Recommendation Report for Planning Permission for Works or Extension to a Dwelling

REF NO: FG/52/22/HH

LOCATION: 6 Beehive Lane
Ferring
BN12 5NL

PROPOSAL: Erection of two storey front extension with front canopy, single storey side and rear extension and extension of loft to habitable use including the installation of 1 x side dormer.

1 PROPOSED GROUND FLOOR
2002 Scale: 1 : 50

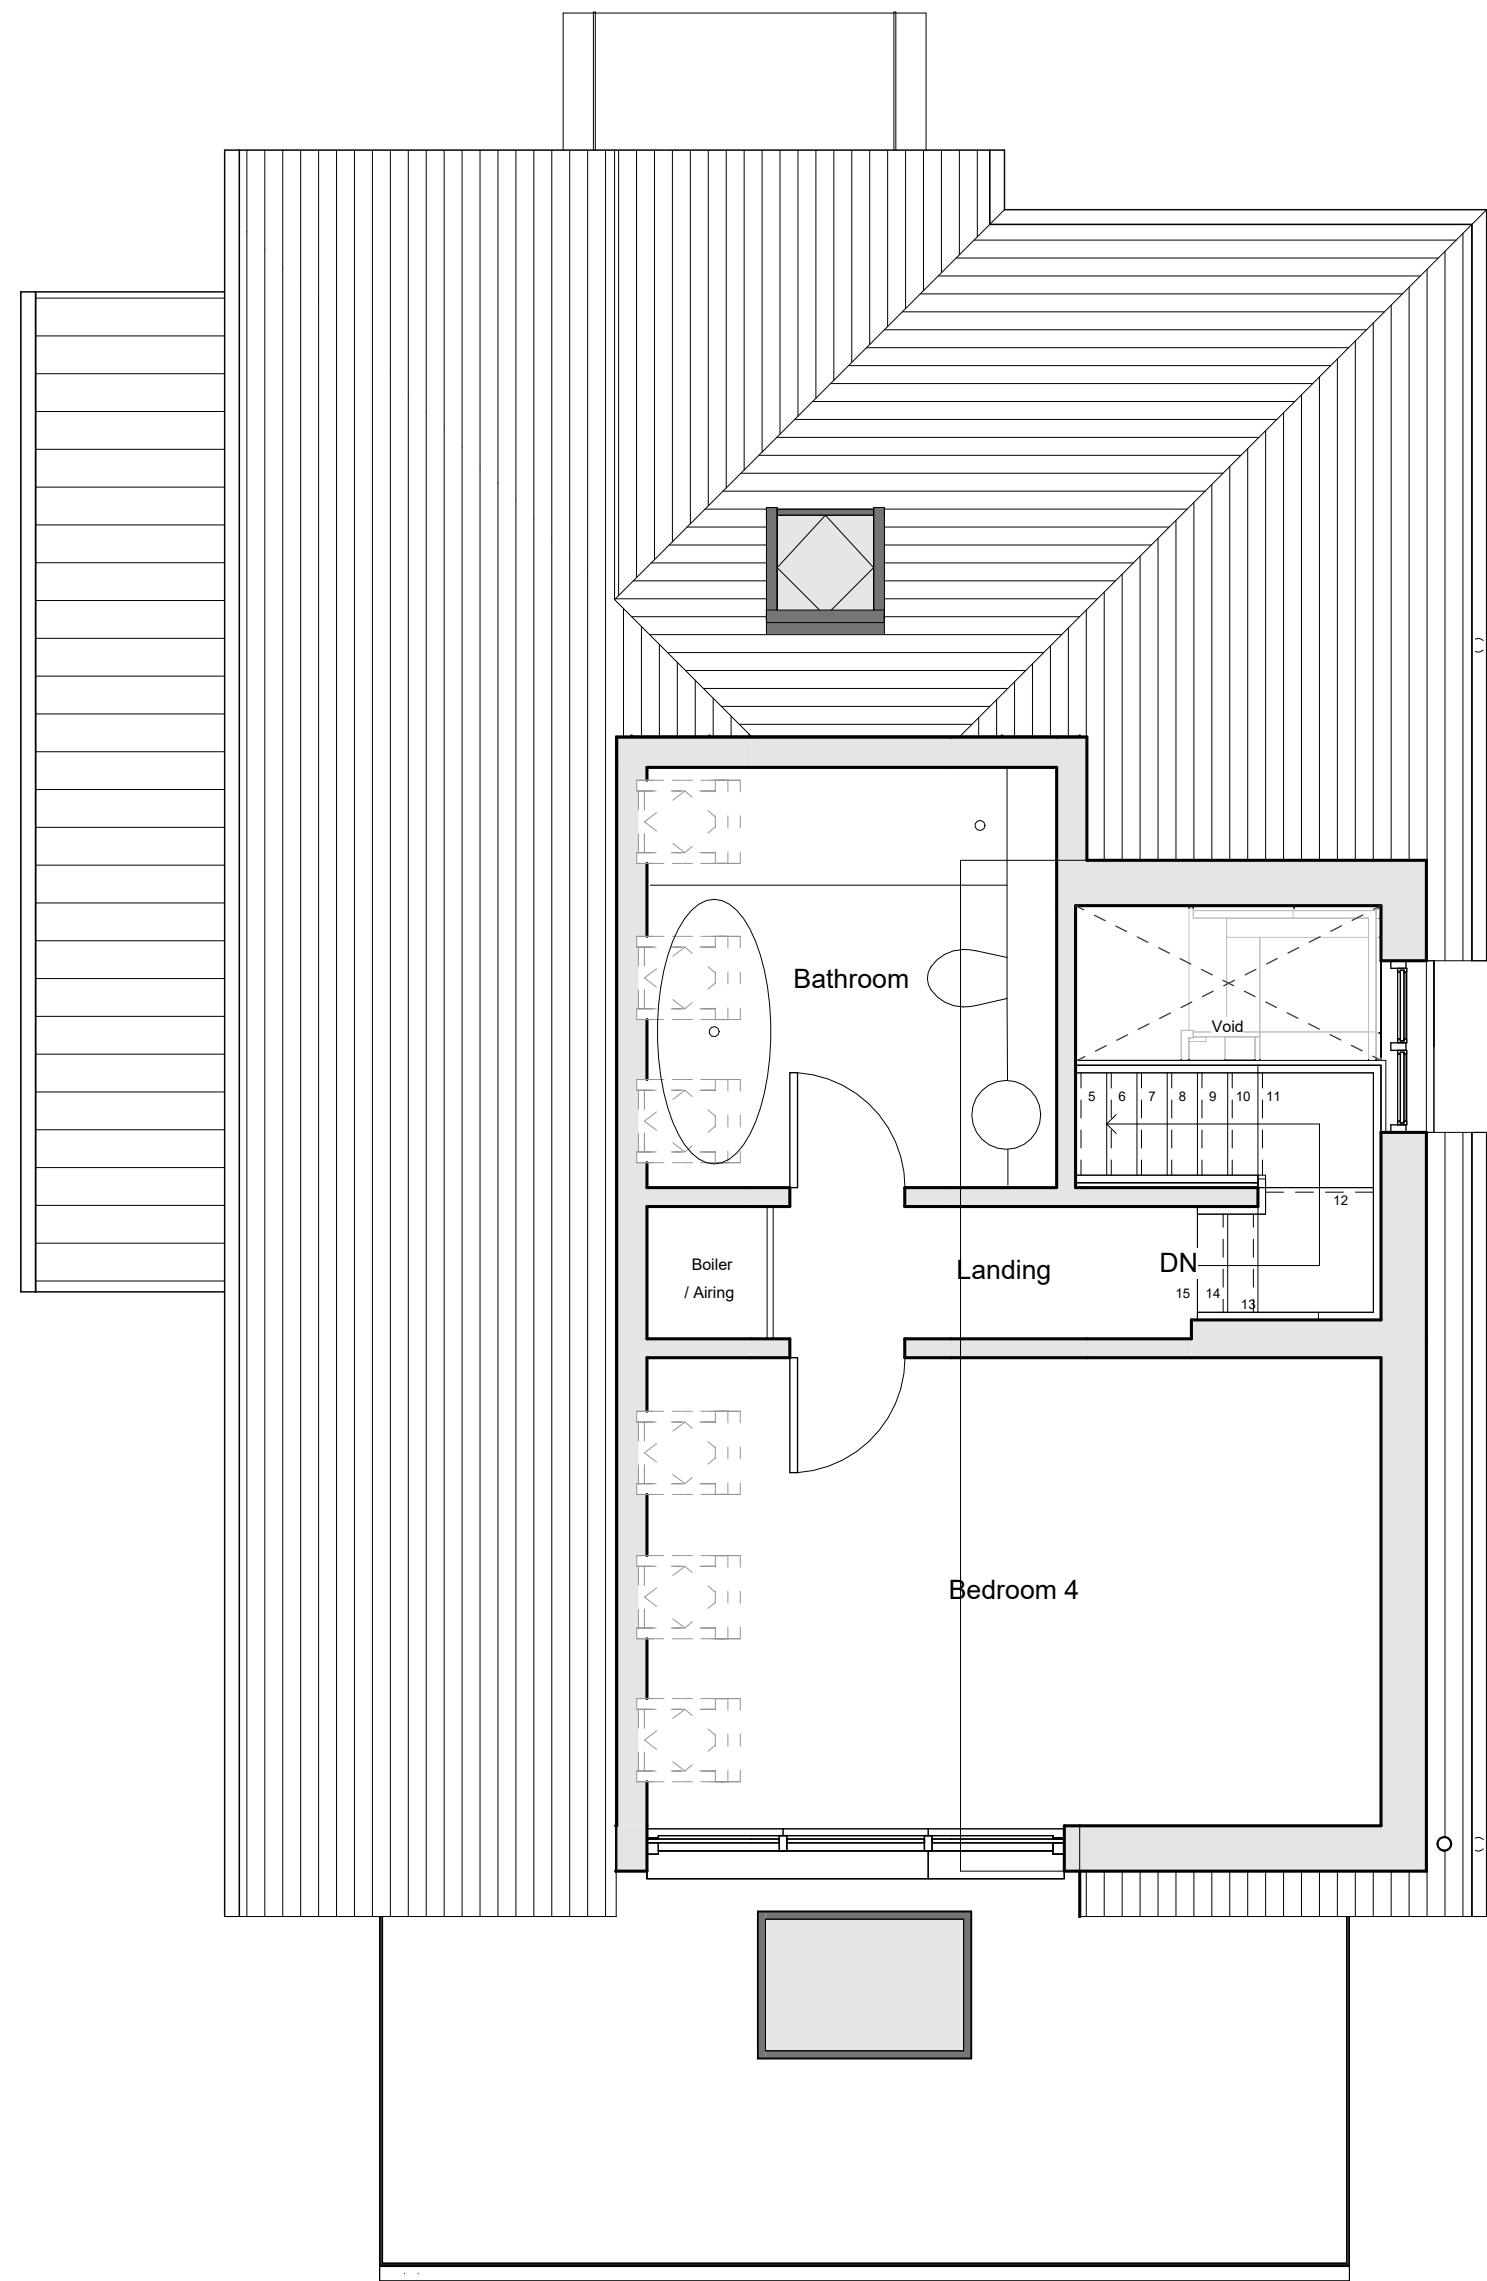
The proposed development will only encroach on the front (north) and side (western) boundaries, no development will extend past the existing line of the eastern or rear elevations. The single-storey side extension sits on the boundary with No 4A as the existing building does. To the west there is a 1.8m separation gap between the building and the shared boundary.

The single-storey side extension and two-storey front extension by reason of their location on site, orientation and scale are not considered to be overbearing or overshadow the neighbouring property to the west.

Comments have also been received regarding concerns for privacy through overlooking. No new views which are not already achievable will be created from any of the proposed fenestration located on the northern or western elevations. The roof lights to the western elevation appear to be above 1.7m from finished floor level, other windows face the public realm. The windows to the east are described within plans as obscure glazed, all other windows above ground floor levels are as existing. The glazed gable to the southern elevation has a direct back-to-back relationship with No 4 Chalet Close. The glazing at first floor level to the southern elevation will be lessening and will therefore improve the situation however, new glazing will be introduced at second floor level. This glazing replaces a much smaller rear gable which is set back by over 1.5m from the rear line of the elevation, by moving the glazing forward the 1.5m only 19m is retained between the two facing elevations, without control this would provide an unacceptable form of development. This window along with the other side windows/veluxes mentioned above will be conditioned to be non-opening and obscure glazed, to protect the privacy of all surrounding neighbours.

- Location and Block Plans 1002
 - Proposed Plans 2002 02
 - Proposed Elevations 2003 02
Reason: For the avoidance of doubt and in the interests of amenity and the environment in accordance with policy D DM1 of the Arun Local Plan.
- 3 The second floor rooflights/windows hereby approved to the western, eastern and southern elevations shall be non-opening and fully obscured windows below 1.7m from finished floor

The first floor window to the western elevation serving Bedroom 2 shall be a non-opening and fully obscured window below 1.7m from finished floor level prior to the first use of the rooms. The window shall be retained as obscure glazed/non-openable in perpetuity.
